Approval of details reserved by condition imposed under ref CM/51/20/L relating to Condition Nos - materials and finishes, 2 - handrails and balusters and 3 - information regarding walls of light well and any safety features.

Kents Farm House Brookpit Lane Climbing BN17 5QU

Arun District Council have decided to **REFUSE details reserved by condition for the following reasons:**

Drawing Title
**WINDOW AND DOOR
DETAILS**

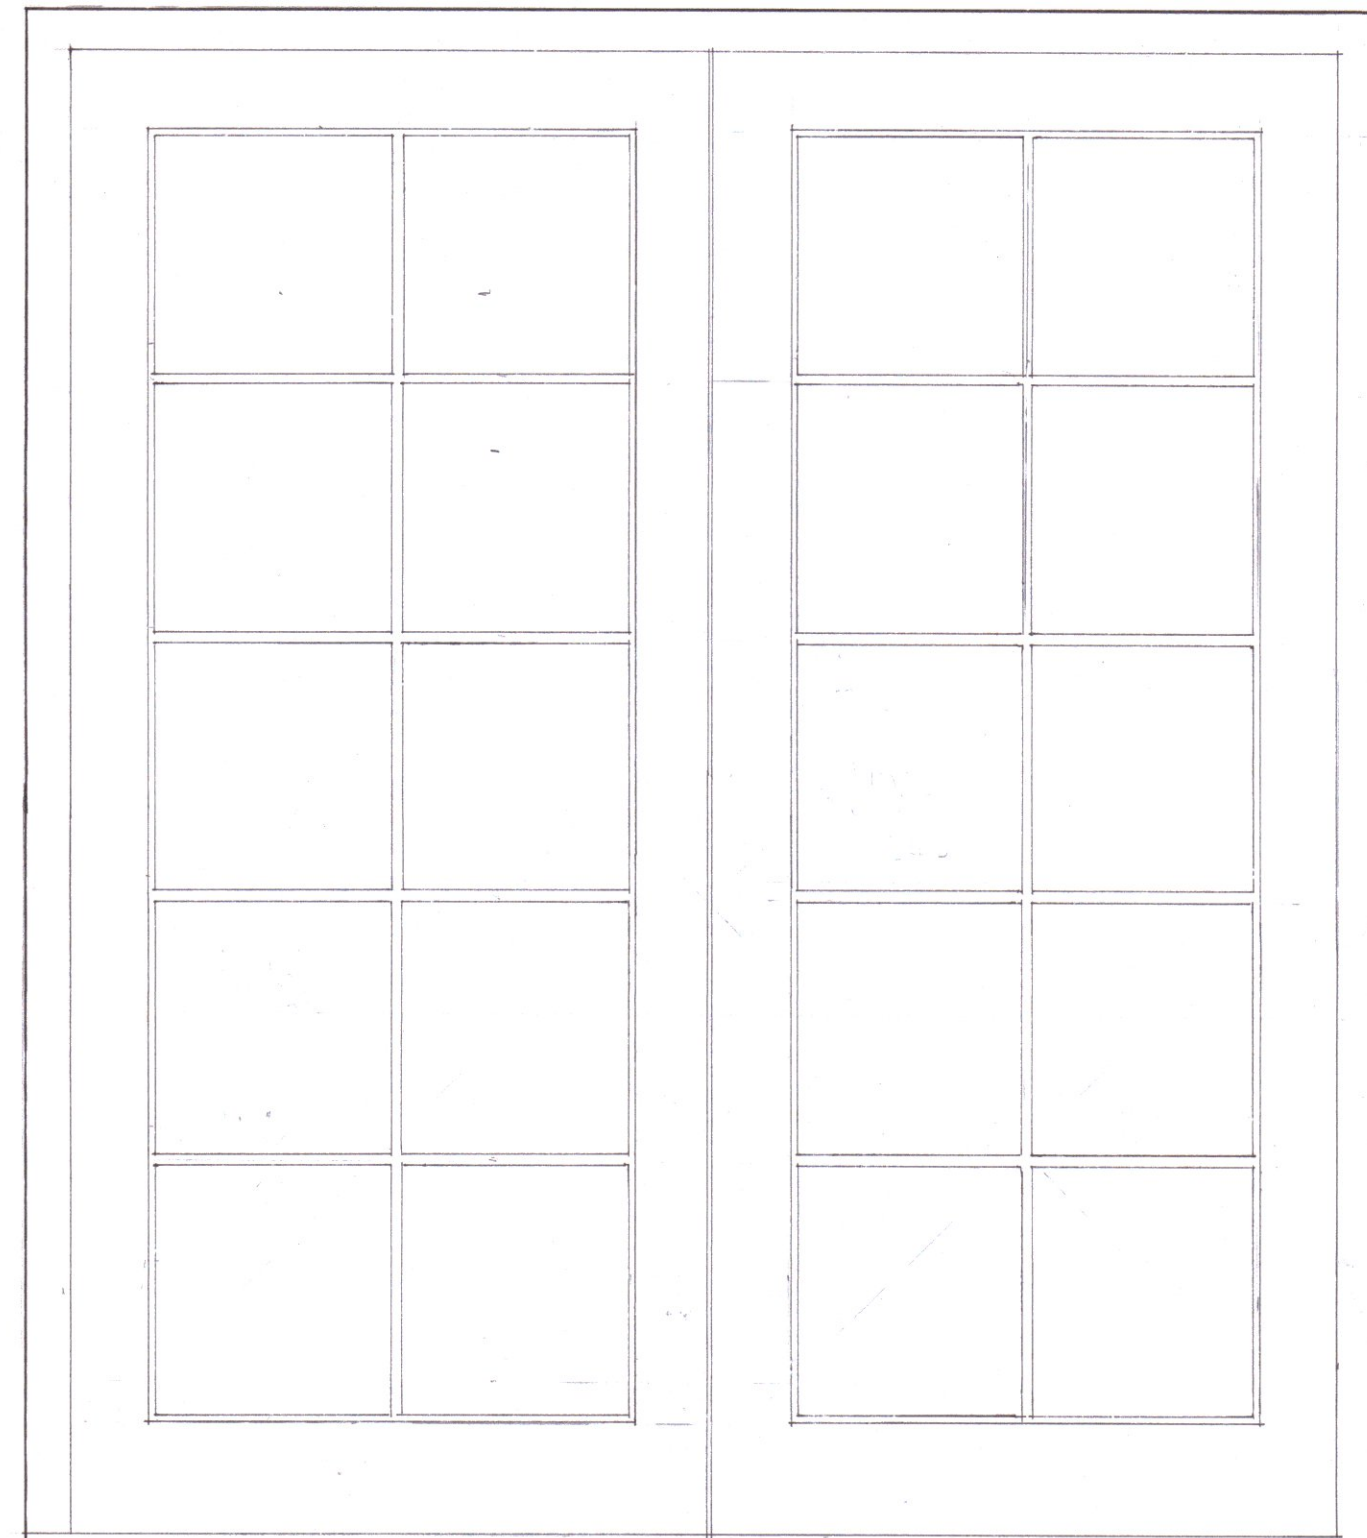
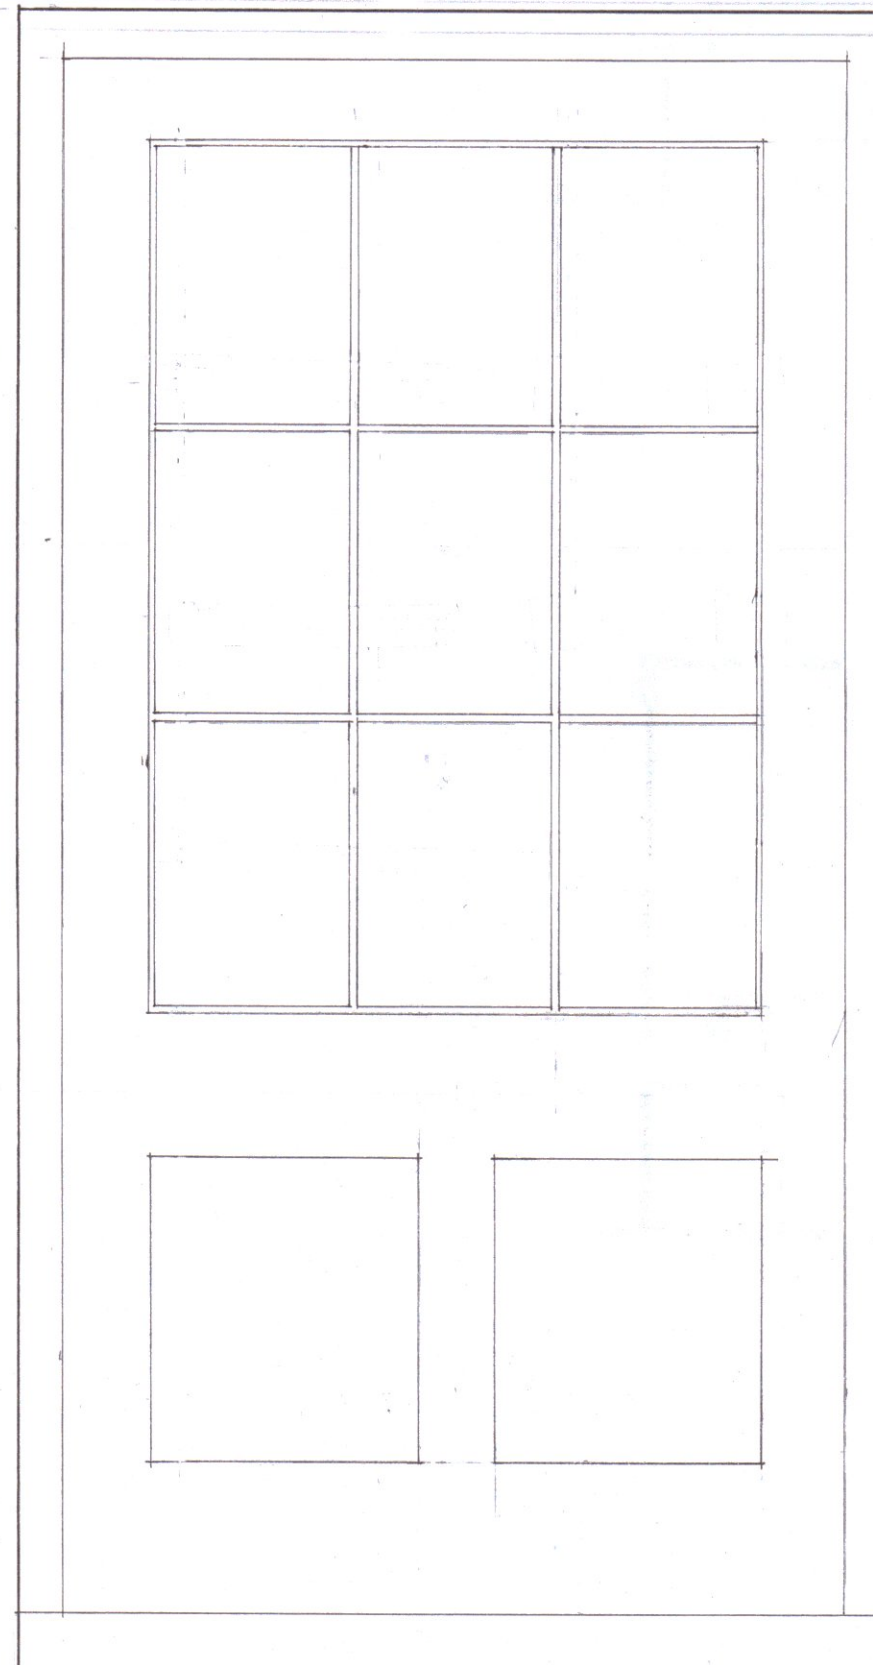
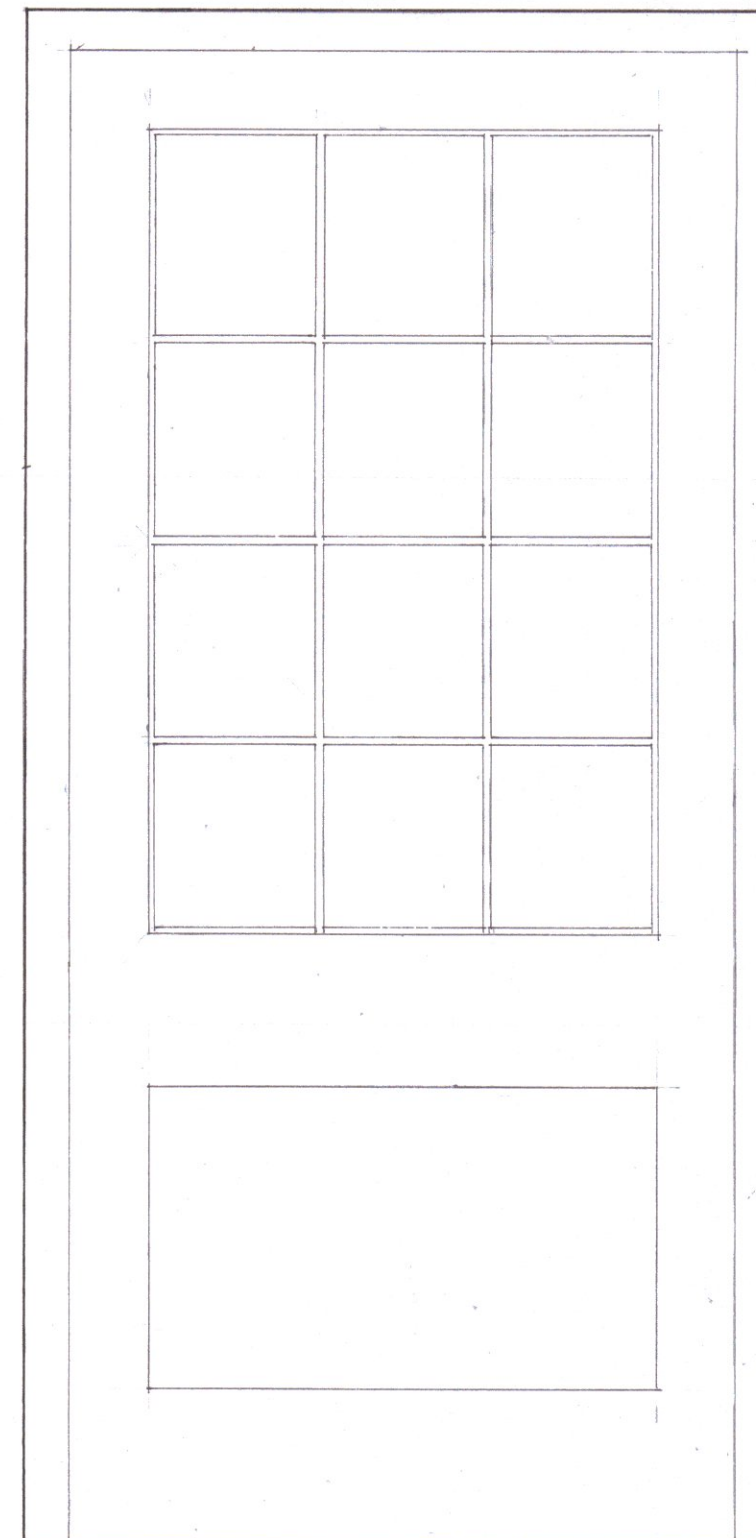
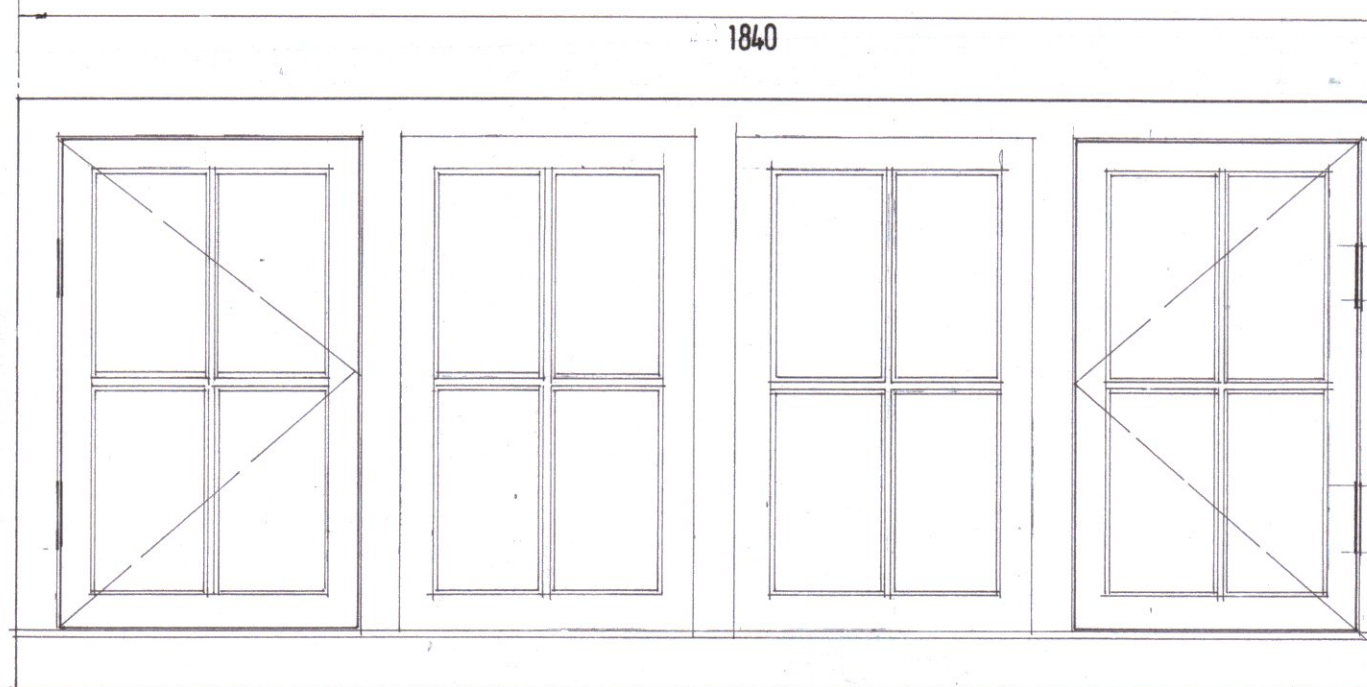
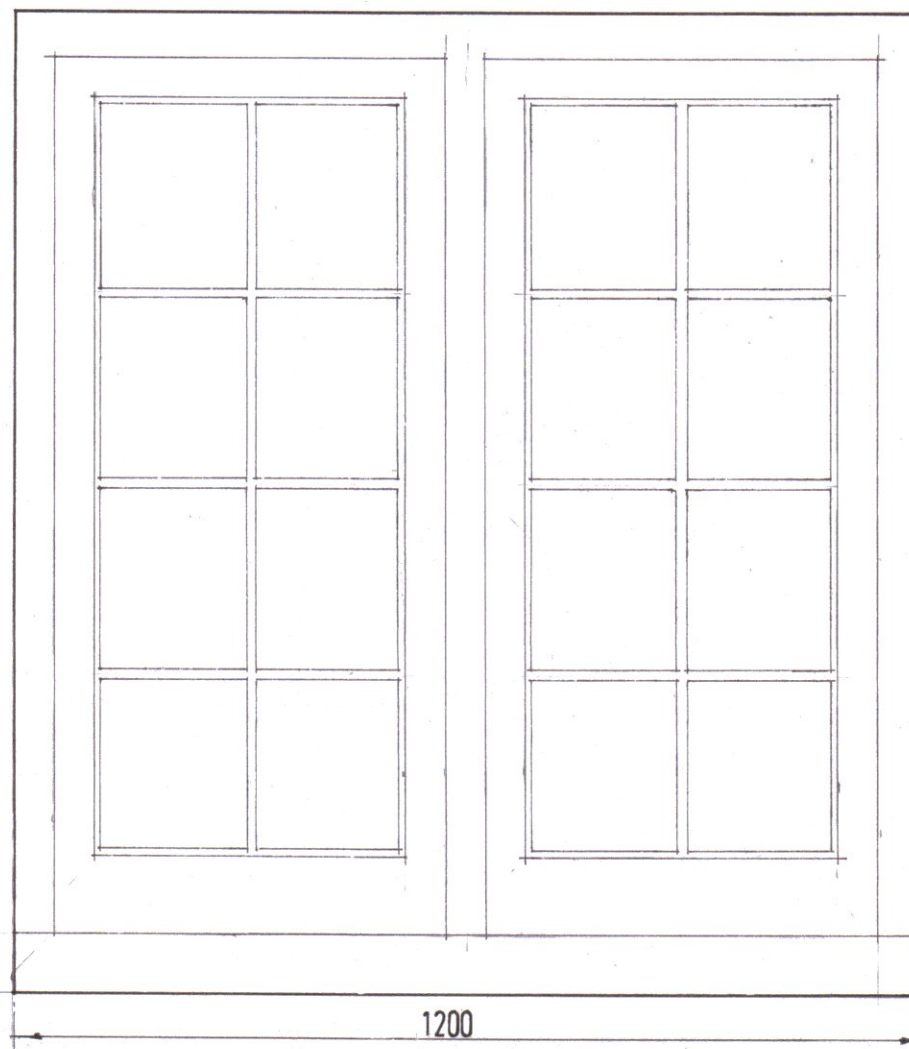
Insufficient information has been provided to discharge condition 1 with regards to details of any new or replacement windows and doors including the material, decorative/protective finish, glazing, cross section of frame, glazing bars and details of any vents and their locations for the boiler and any other systems required for ventilating the bathrooms required by condition 1 of CM/51/20/L.
